PLOT PLAN / SPECIAL USE DRAWING

Add PCD File No. AL196

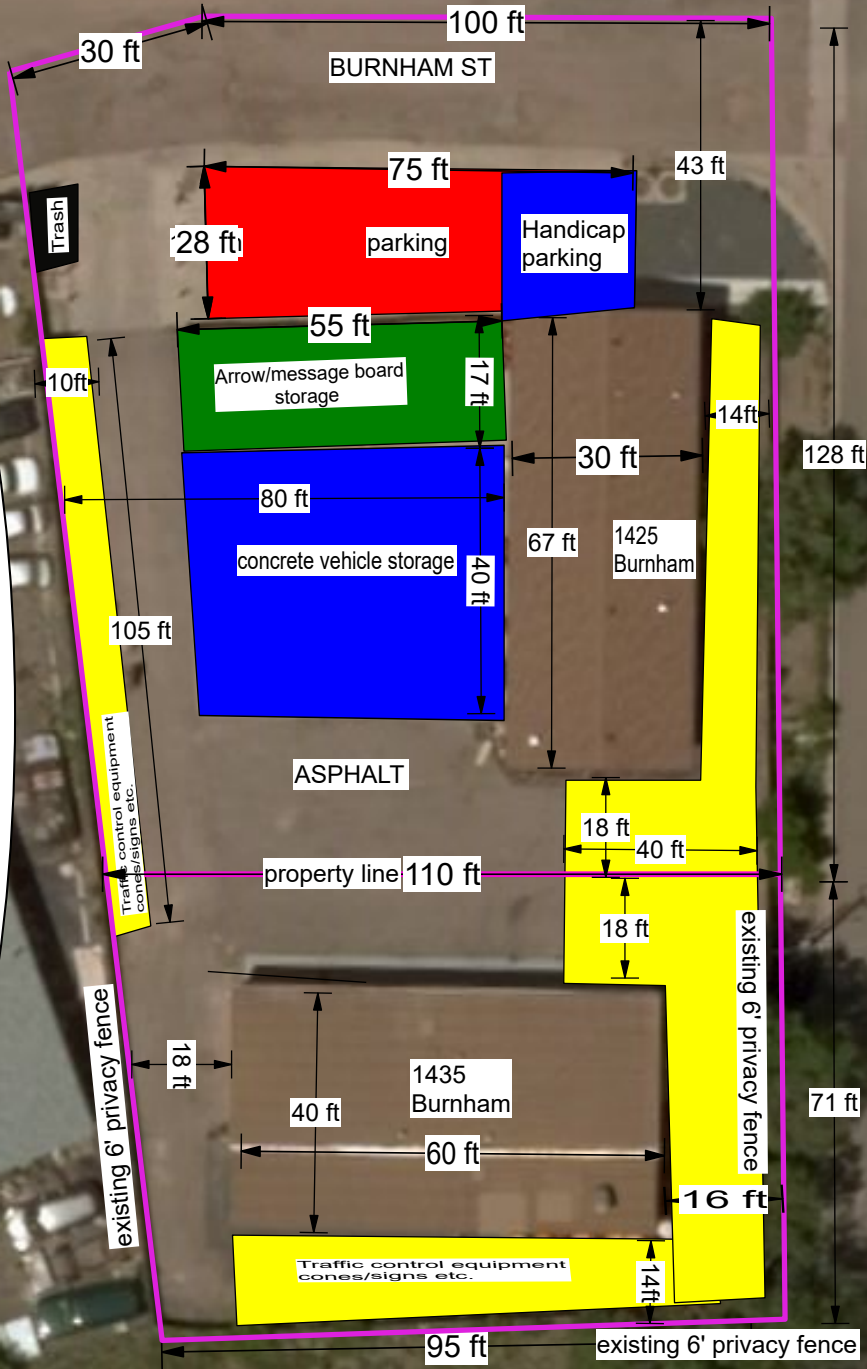
Identify all vehicle storage areas.
Show setbacks from buildings to nearest property line.

Show property boundaries on this plan. Designate vehicle storage area. Add North arrow.
